WATERVIEW EAST PRELIMINARY PLAN

LOCATED IN A PORTION OF SECTION 9, T15S, R65W OF THE 6TH P.M.,
EL PASO COUNTY, STATE OF COLORADO

WATERVIEW EAST PRELIMINARY PLAN		
Designer: BG	Structure Numbers	Project No./Code 181710214
Detailer: PF		
Sheet Subset:		Sheet Number 1 of 9

Project No./Code	181710214
Sheet Number	5 of 9

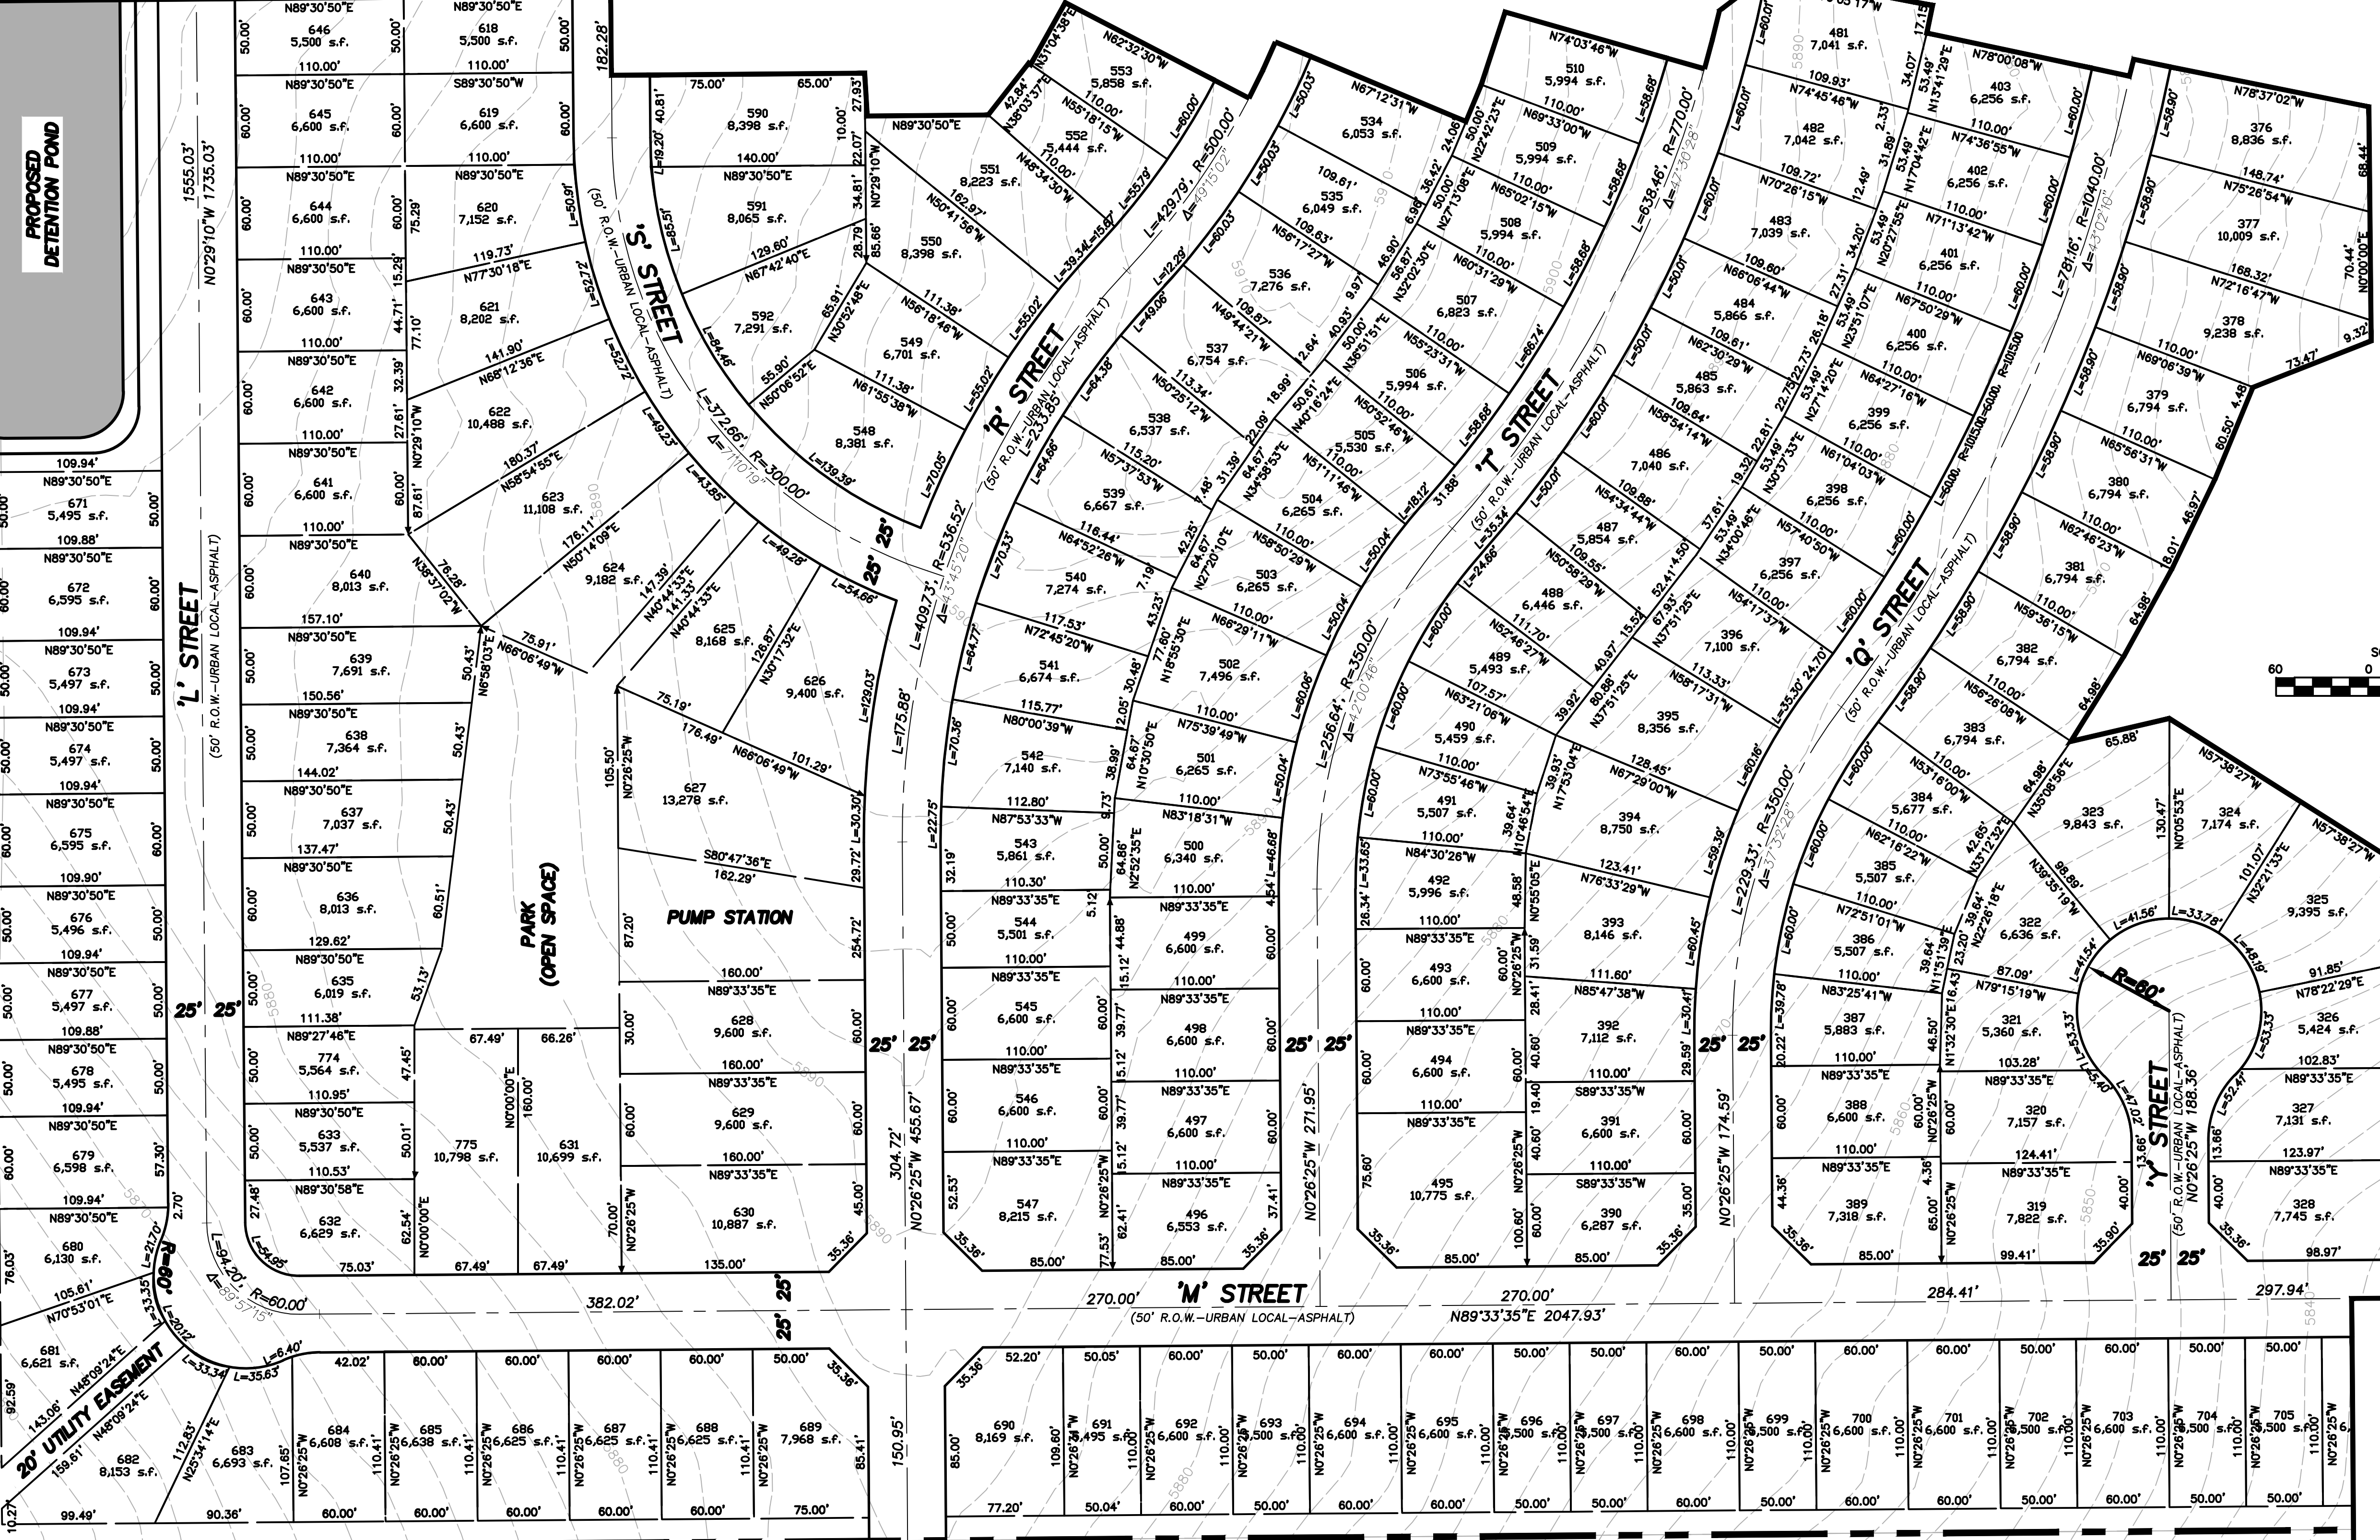
Show the sight triangle on the intersections. See ECM 2.3.6.G.

Locate all sight triangles that encroach into lots within a sight distance easement.

The easement shall be dedicated to the County. Maintenance of a sight distance easement shall be the responsibility of the property owner.

Label all tracts

Project No./Code	181710214
Sheet Number	8 of 9

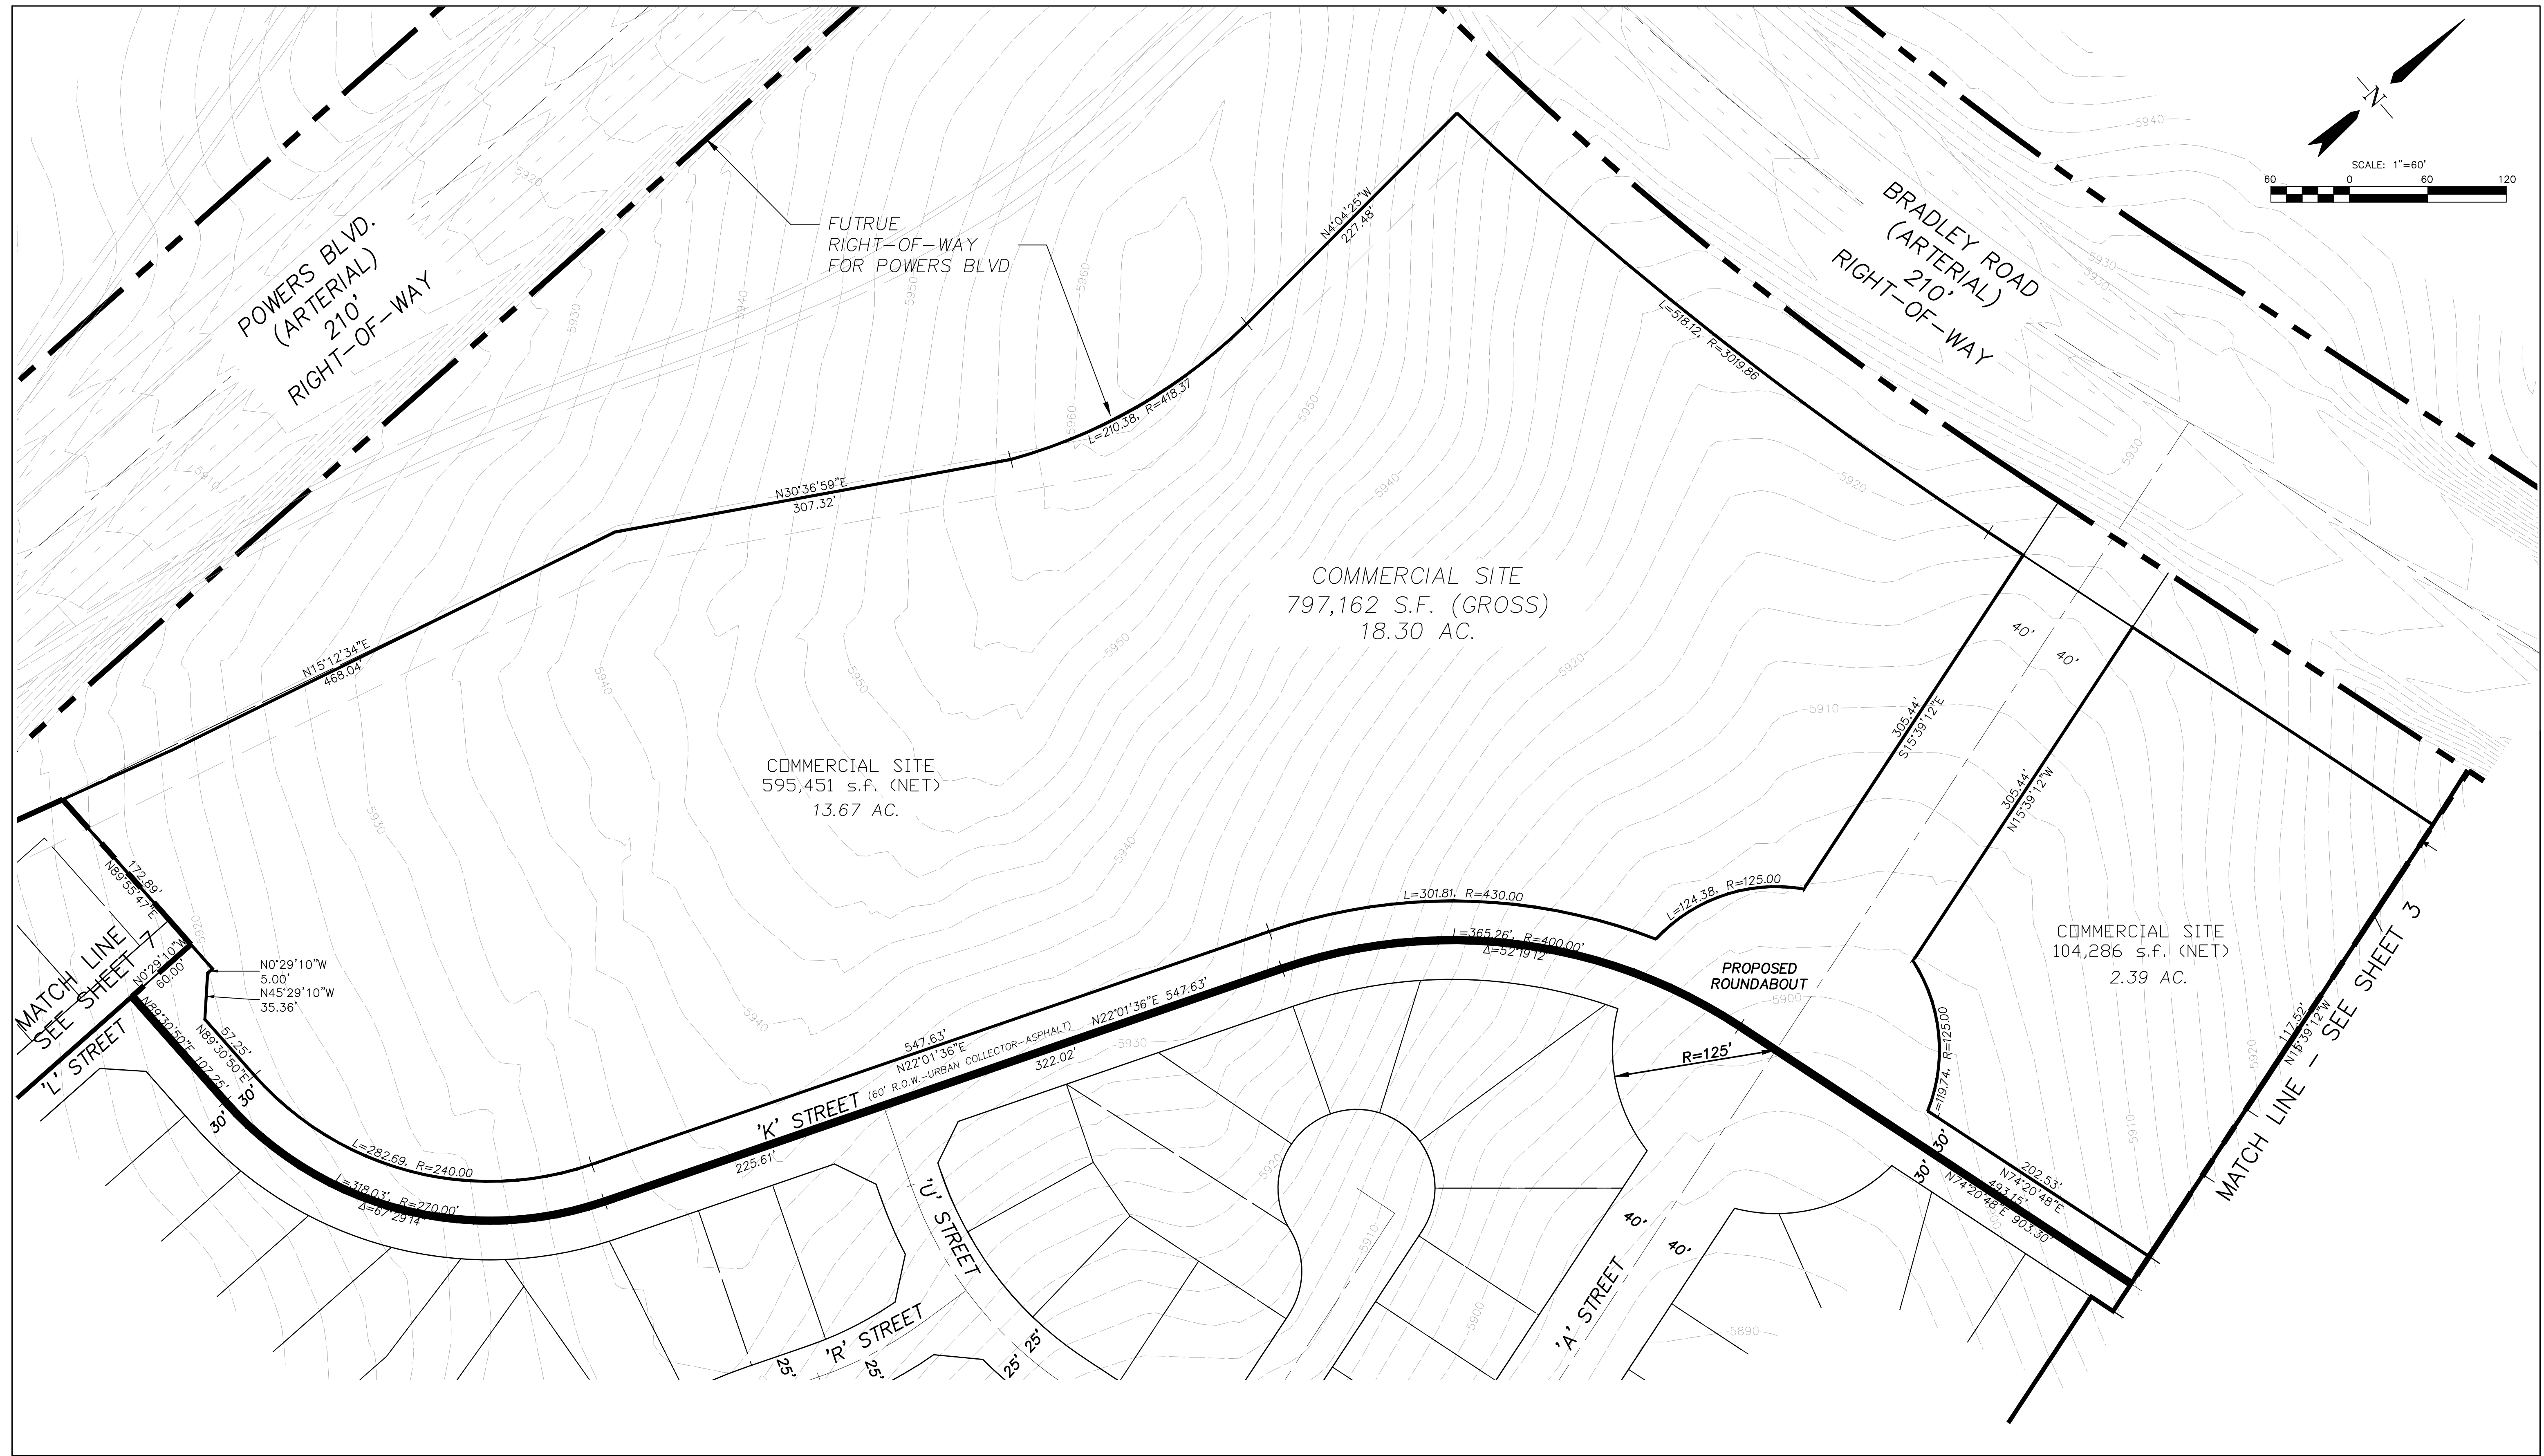
Does not meet the minimum intersection spacing.

Label the intersection spacing. It appears to be right at the minimum requirement.
